Item No. **Report of the Head of Planning, Transportation and Regeneration**

Address 41 LANNOCK ROAD HAYES

Development: Part two storey, part single storey side and rear extension and porch to front involving demolition of existing extension

LBH Ref Nos: **40857/APP/2020/1915**

PROPOSED FRONT ELEVATION
SCALE= 1:100

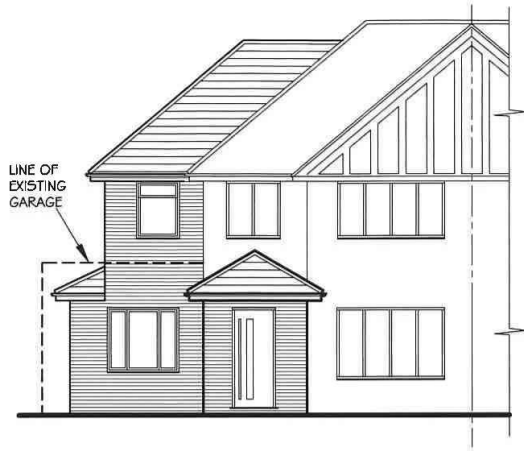
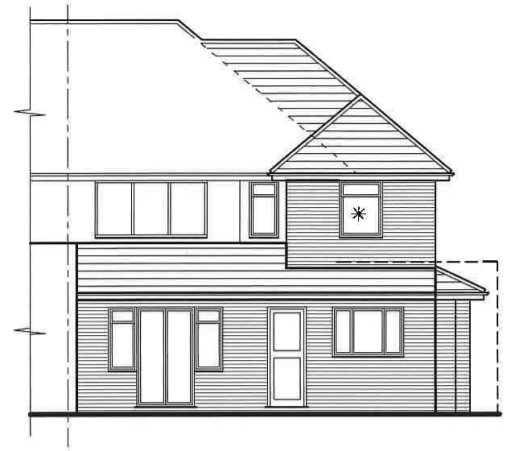
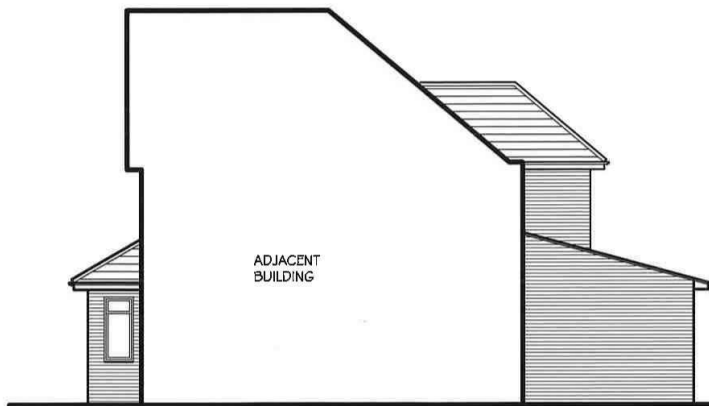
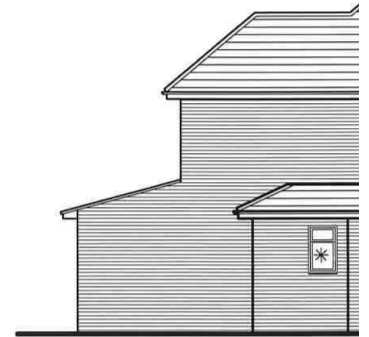
The proposal would involve the replacement of the existing single storey side extension and its replacement with the part two storey, part single storey side extension. The proposed first floor would be set back by 1m from the front elevation. Given that the existing side elevation would be removed, the proposal does not strictly comply with the requirements of Policy DMHD 1. However, consideration is given to the visual harm caused to the character and appearance of the host dwelling, pair of semi-detached properties and locality. The application property is one side of a pair of semis. The adjoining property also has a side extension in line with the front wall of the original dwelling. It is considered that the lack of set back from the front elevation of the property at ground floor level would not unacceptably unbalance this pair of semi's. The proposed side extension would not exceed half the width of the original dwelling and would appear as a subordinate extension.

The proposal includes the addition of a porch which would project considerably beyond the front projecting bay of this semi-detached dwelling, which is mirrored by the adjoining dwelling. The porch would be attached to the replacement side extension and when considered cumulatively, fails to appear sympathetic to the architectural integrity of the host dwelling or the symmetry of the pair of semi-detached properties. As such the proposal would result in an incongruous form of development within the streetscene in conflict with policies DMHB 11 and DMHD1 of the Hillingdon Local Plan - Part Two (2020).

The proposed front porch/extension in combination with the side extension, by reason of the size, scale, bulk, width and design would appear as an overly dominant and incongruous form of development which would fail to harmonise with the architectural composition of the original dwelling, would be detrimental to the character, appearance and symmetry of the pair of semi-detached houses and to the visual amenities of the street scene and the surrounding area. Therefore the proposal would be contrary to Policy BE1 of the Hillingdon Local Plan: Part One - Strategic Policies (November 2012) and Policies DMHB 11, DMHB 12 and DMHD 1 of the Hillingdon Local Plan: Part Two - Development Management Policies (January 2020).

PROPOSED GROUND FLOOR PLAN
SCALE= 1:100

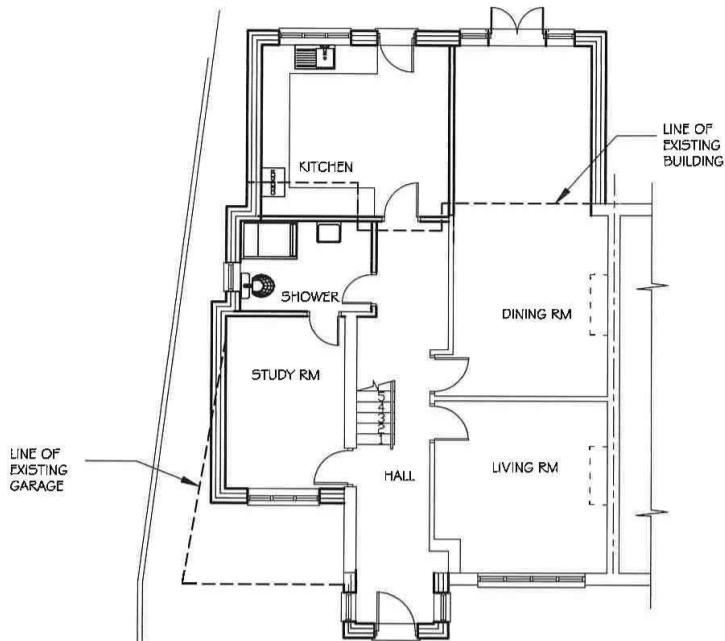
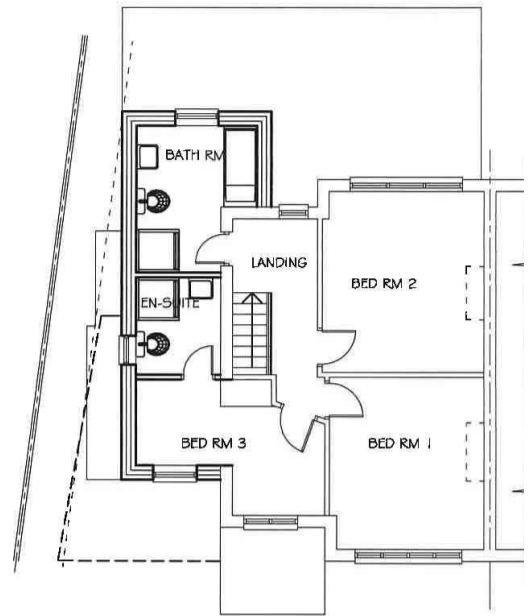
The proposals are not considered to result in an unacceptable loss of light or outlook to occupants of the adjoining and adjacent properties. A condition to ensure retention of the obscure glazing and to ensure no additional windows would protect neighbours from any loss of privacy.
